To: Lindsey Stuart (East Lindsey District Council)
From: Royal HaskoningDHV
Date: 08 April 2024
Copy: Job File
Our reference: PC3999-WM-ME-240402-1420
Classification: Project related
Checked by: Paul Salmon

Subject: Viking CCS Pipeline Environmental Impact Assessment Report Review

Royal HaskoningDHV has been commissioned by East Lindsey District Council (ELDC) to review selected elements of the Environmental Statement (ES) on their behalf pertaining to the Development Consent Order (DCO) application for the Viking CCS Pipeline project by Chrysaor Production (UK) Limited.

ISSUE PURPOSE
 DCO APPLICATION
PROJECT NUMBER / REFERENCE
 60668955 / VCCS_231002_DCO_6-9-3

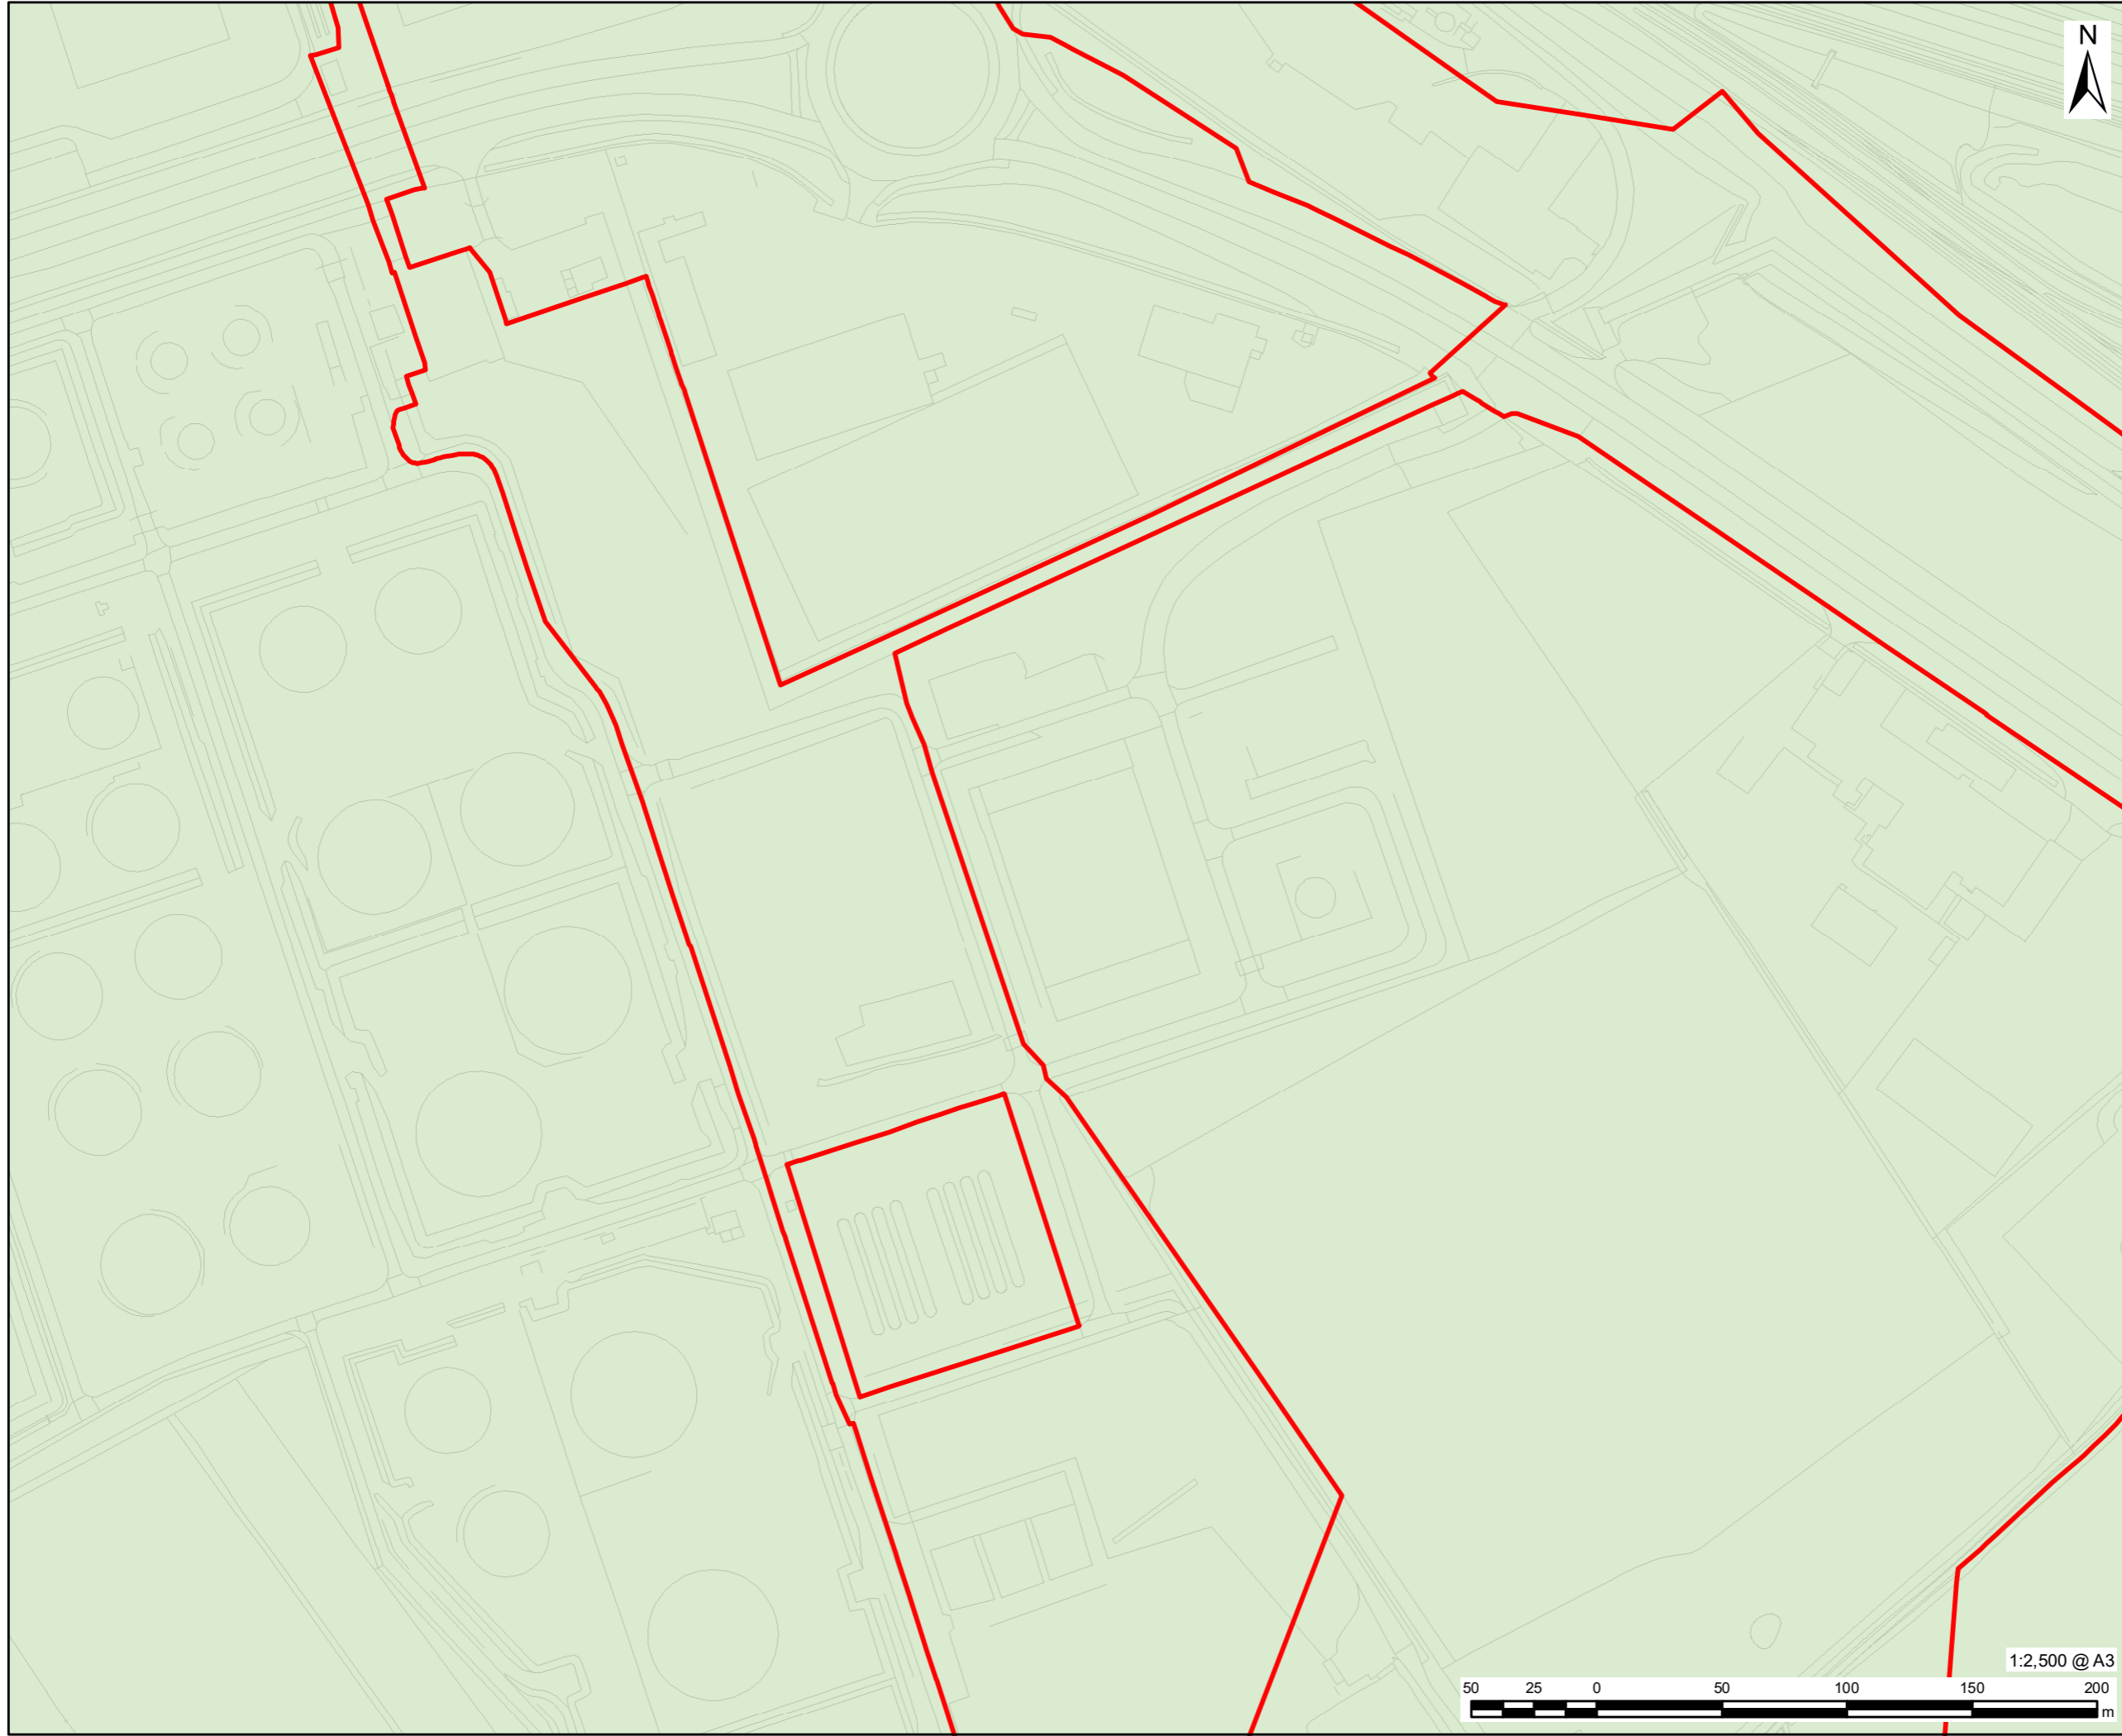
- With regards to Table 11-10 'WFD Study Waterbody Status within study area of the DCO Site Boundary (Cycle 3)', updates are required in order to show the latest 2022 status updates for Cycle 3 as the table currently contains data from 2019.
